The Secretary
NSW Department of Planning, Industry and Environment

I refer to the Department's below email of 18 June 2020 regarding Environment regarding State Significant Development SSD-10425 Tallawong Station Precinct South - Stage 2 detailed design application at 1-15 & 2-12 Conferta Avenue, Rouse Hill (Lots 293 & 294 DP 1213279) in the Blacktown LGA. Submissions need to be made to the Department by 22 July 2020.

Cornelis Duba

Development Application Specialist
Network Environment & Assessment

FIGURE A5 FLOOD LEVEL DIFFERENCE – 1% AEP

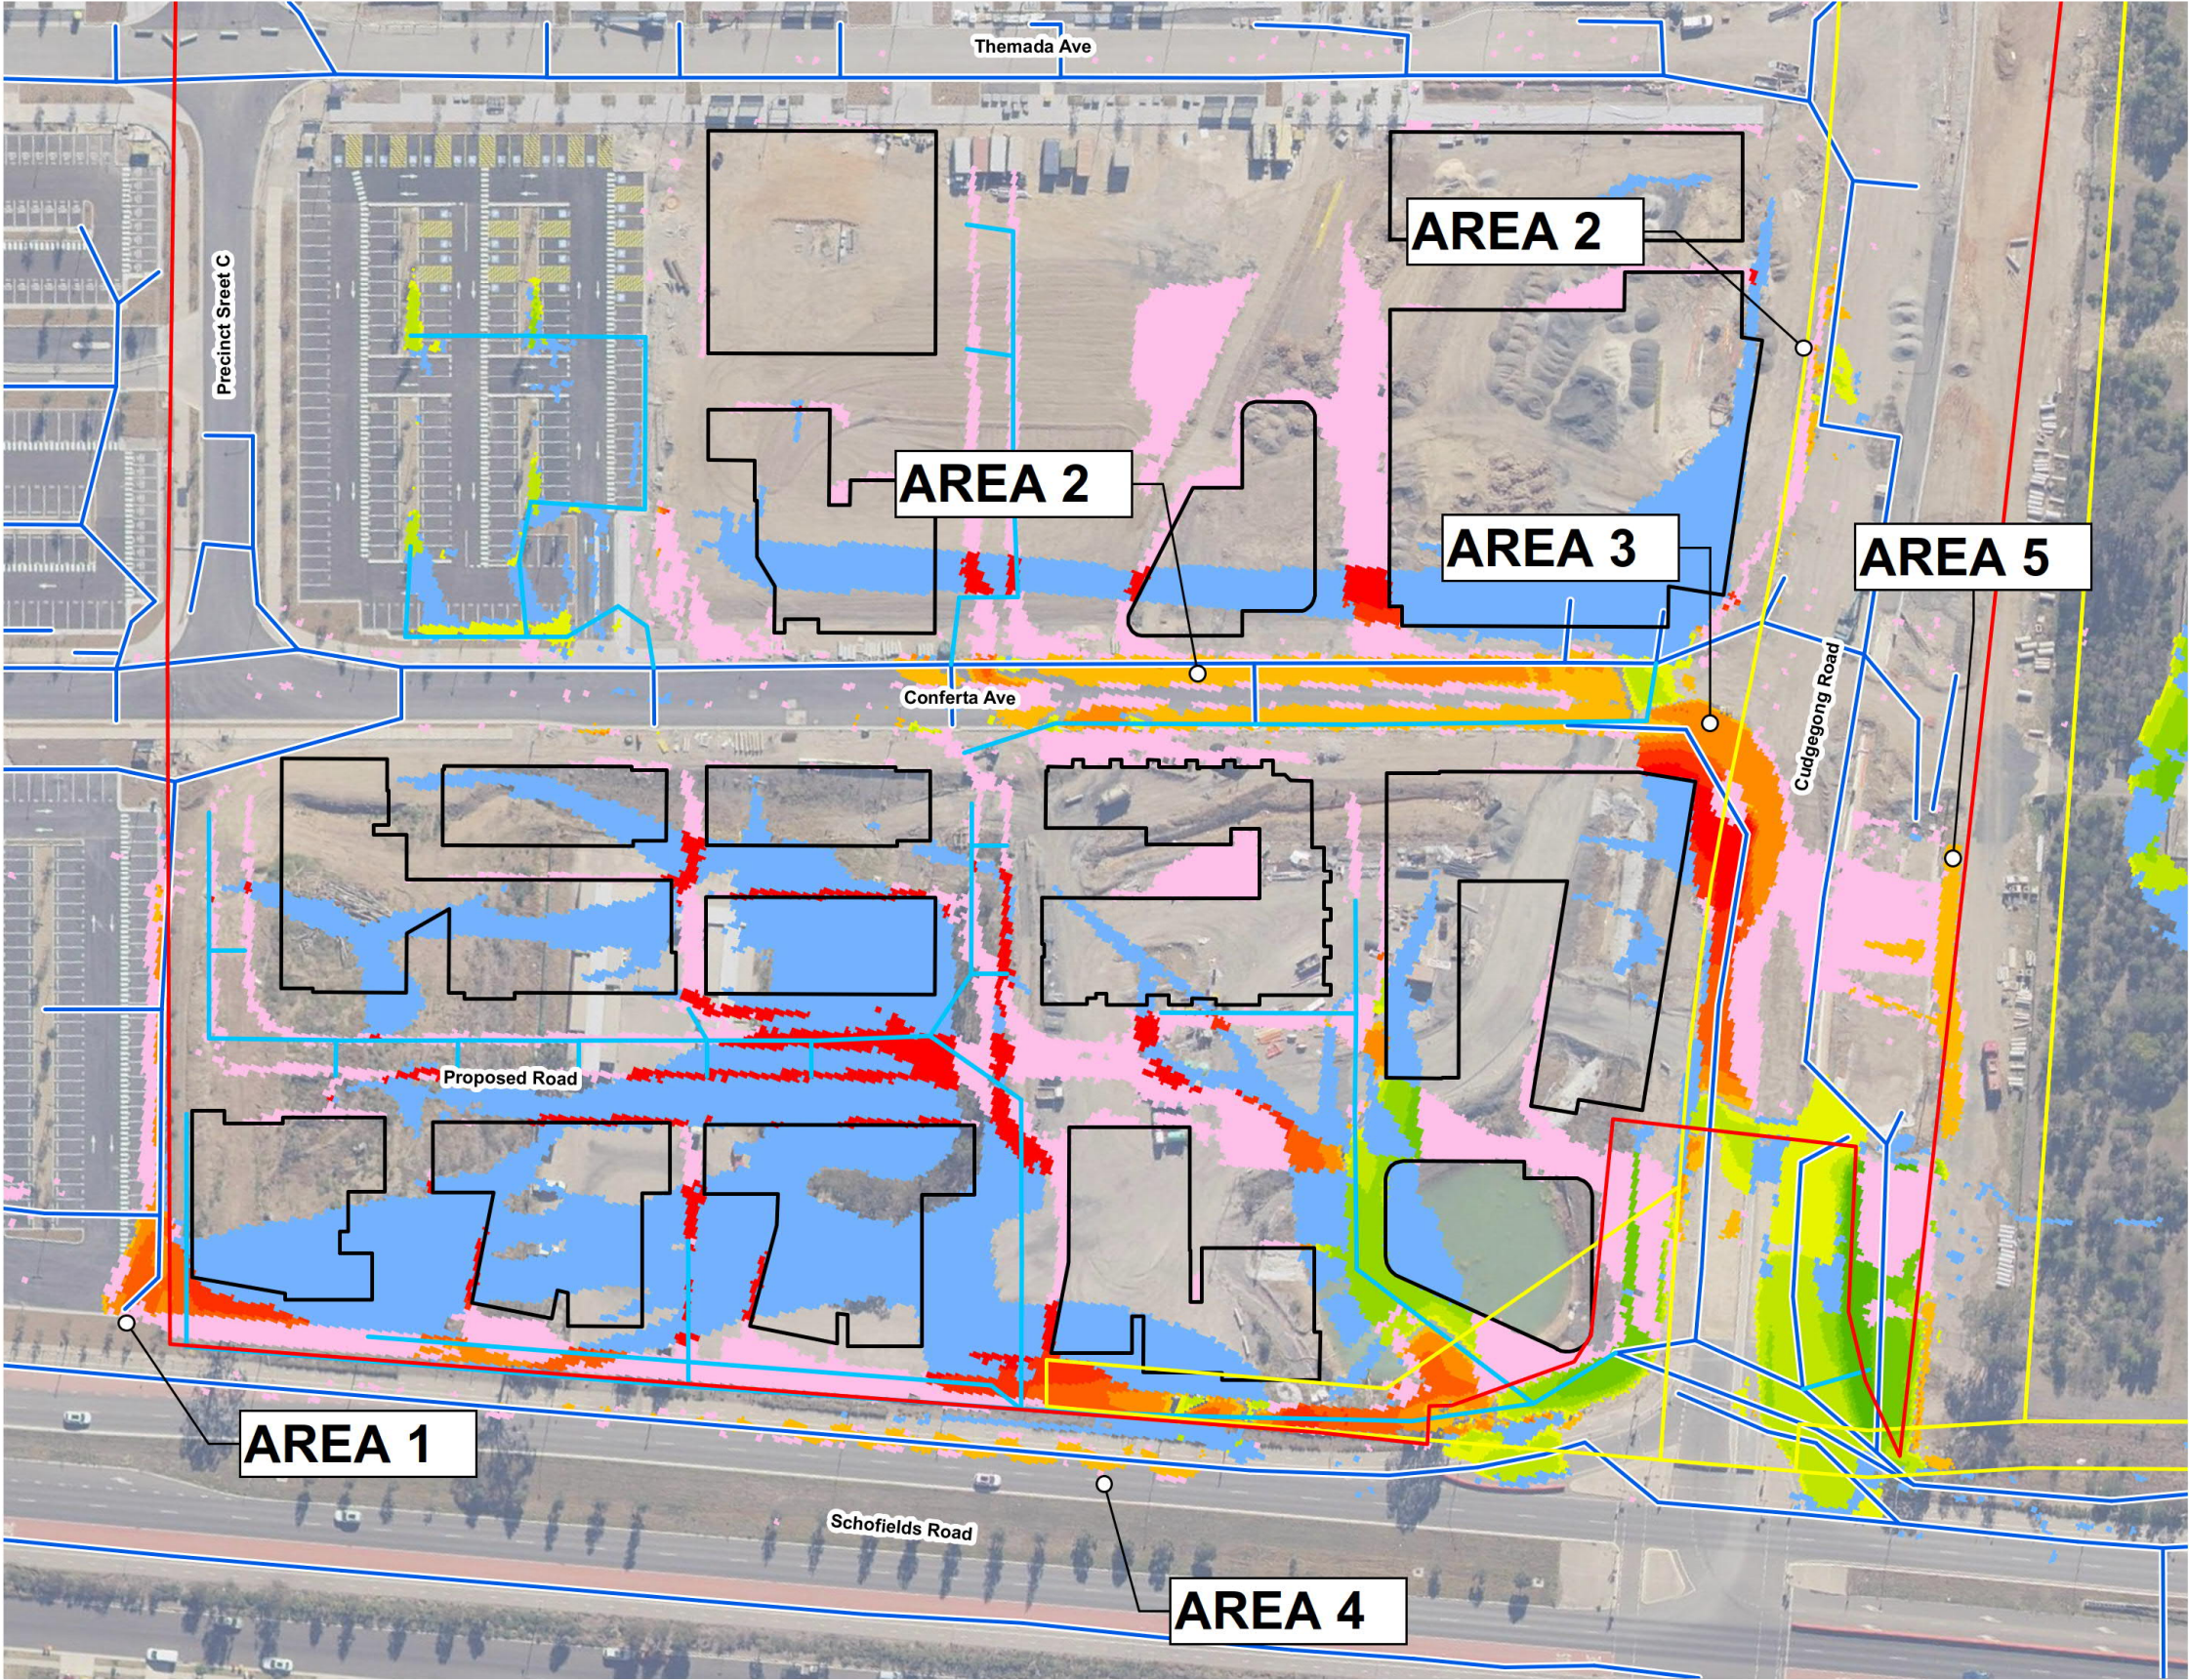
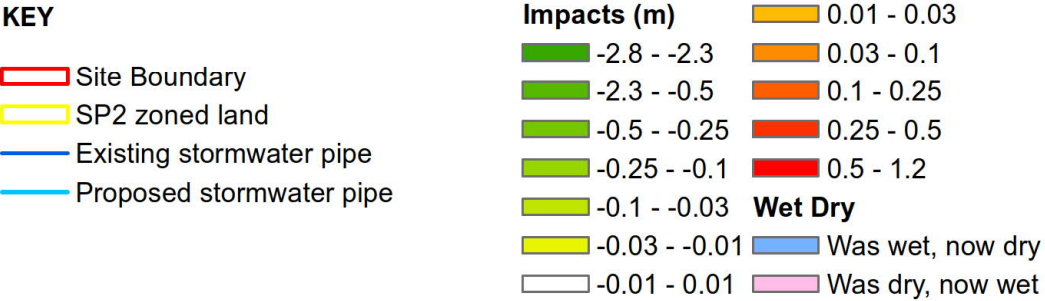
Whilst the Flood Impact Assessment does address the likely flood impacts on ‘Area 5 – Council Owned SP2 Lands’ being the area east of Cudgegong Road, it does not appear to specifically address the Rouse Hill Switching Station site which is also located to the east of Cudgegong Road. The Assessment indicates there will be post development impacts which are deemed to be considered to be acceptable. However, it is imperative that as a result there is no worsening of the existing flood impacts on the nearby properties / existing development. Reducing the effectiveness of flood conveyance or flood storage areas increases the risk of property damage to other parties – which is of particular concern for the Rouse Hill Switching Station. This issue needs to be specifically addressed and Endeavour Energy should determine if any impacts are considered to be acceptable to the Rouse Hill Switching Station.
